Application no: H22/0827/99

Description: Erection of a two storey side
extension

Location: 200 Broadgate
Weston Hills
Spalding
Lincs

Amendment: Lounge and bedroom extended, plus revised fenestration

FIRST FLOOR PLAN

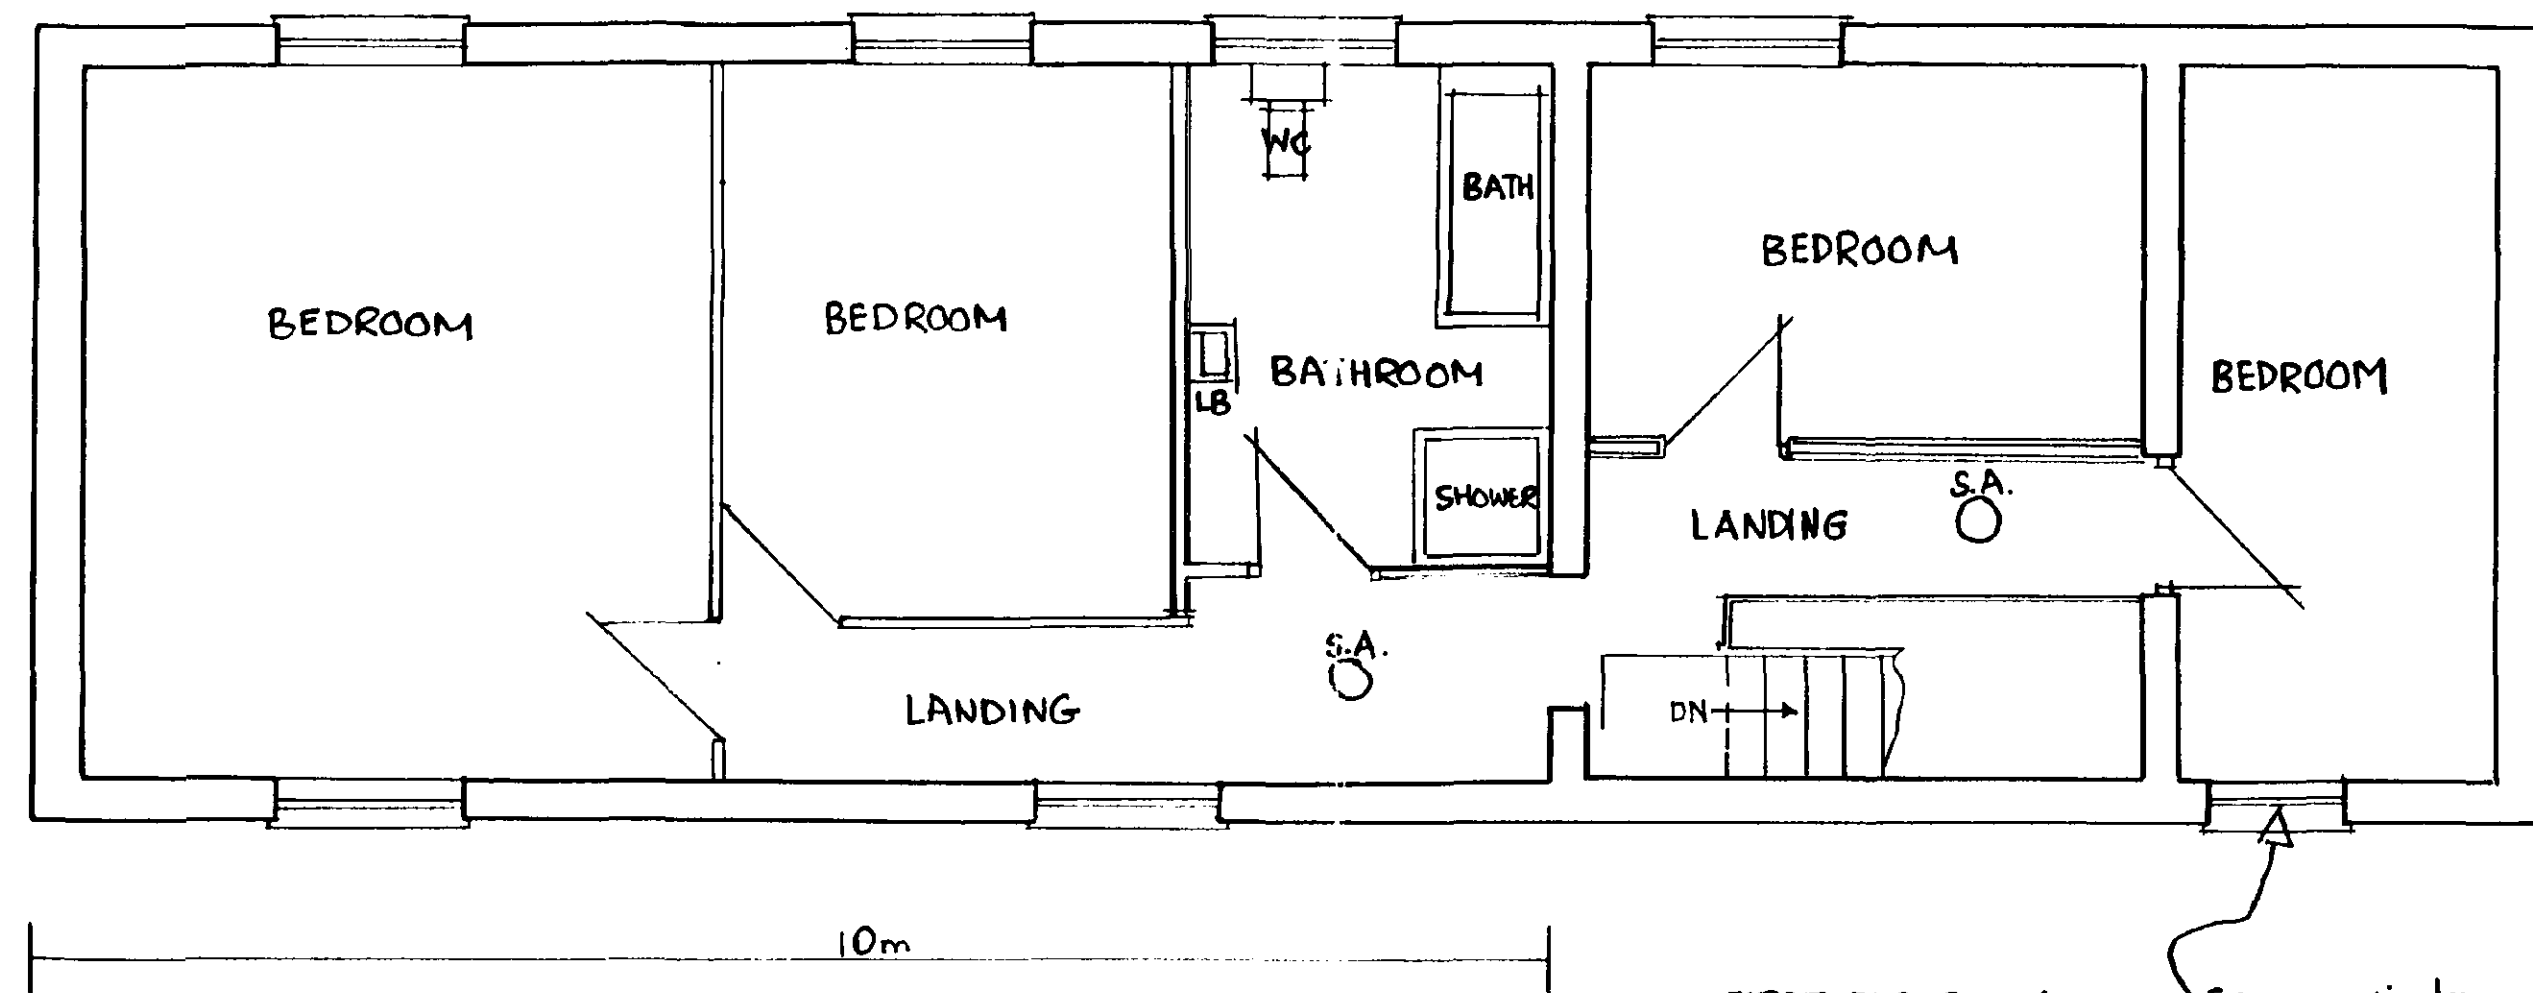
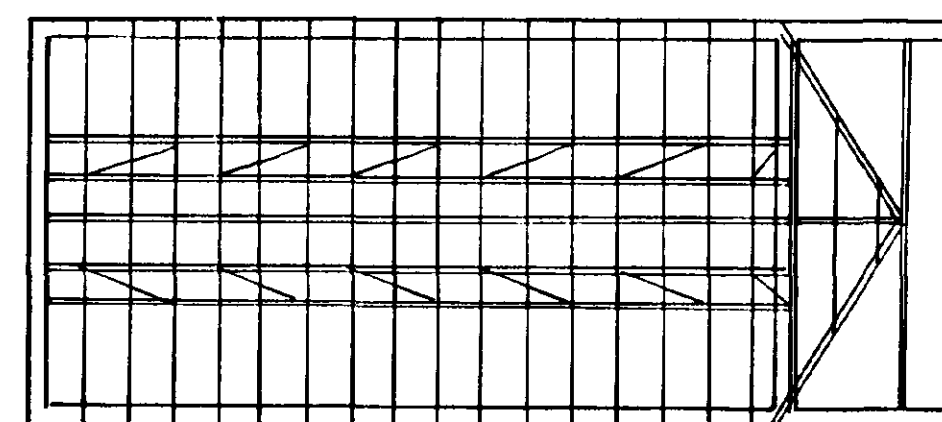
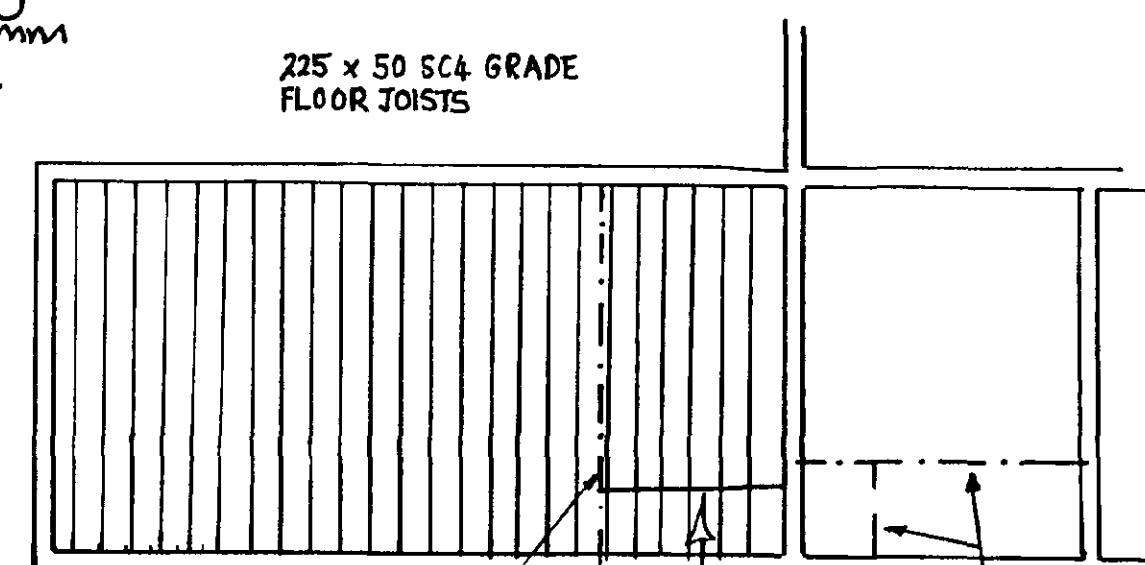
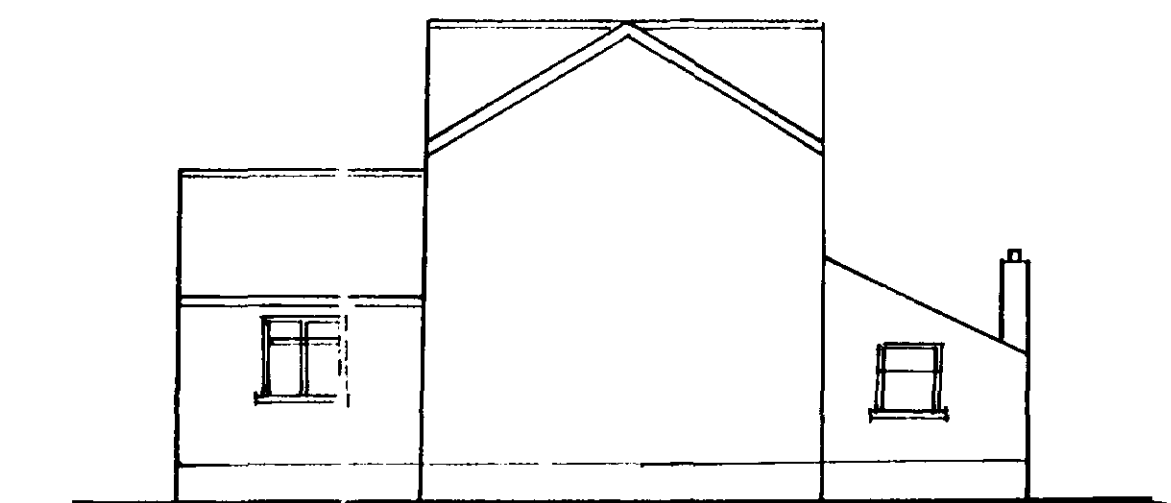
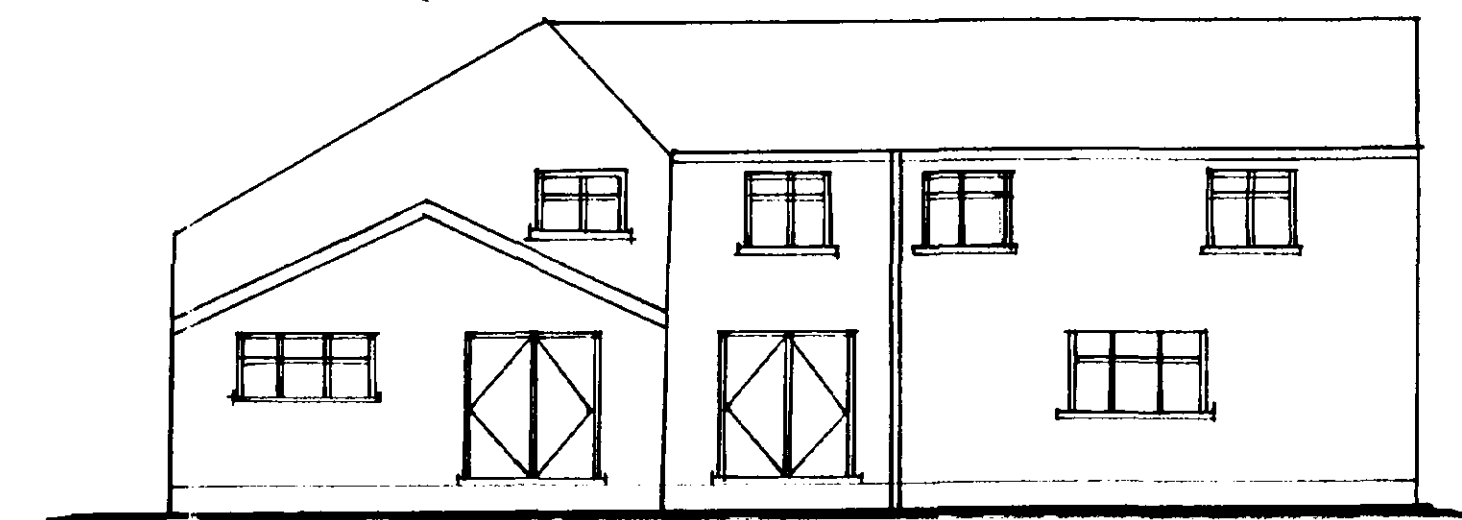
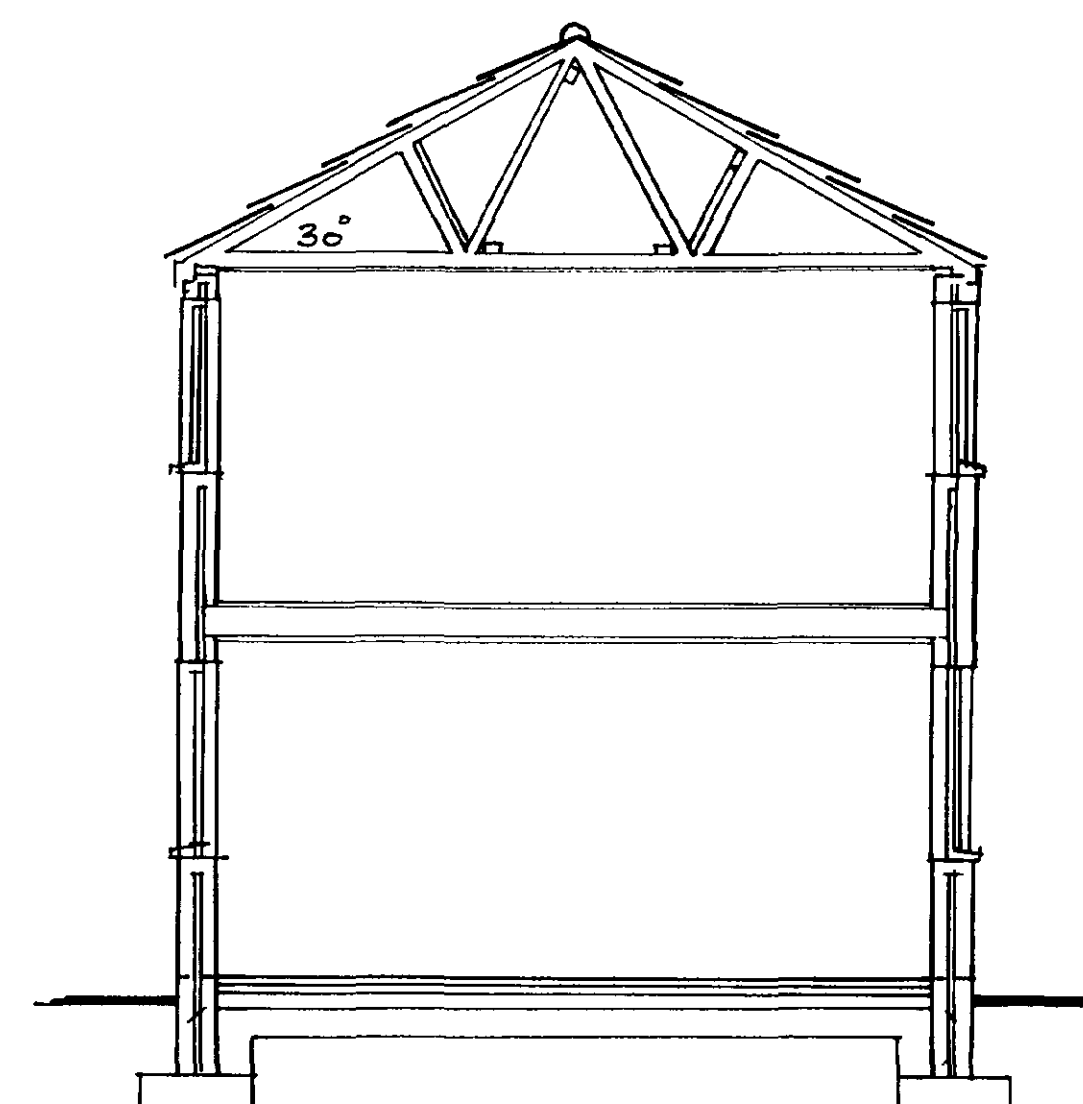
2.5m - two storey
Now proposed 10m
length of extension.

The amended details submitted in respect of the above proposal have now been considered and there are no objections to the amendment being implemented to the extent described above.
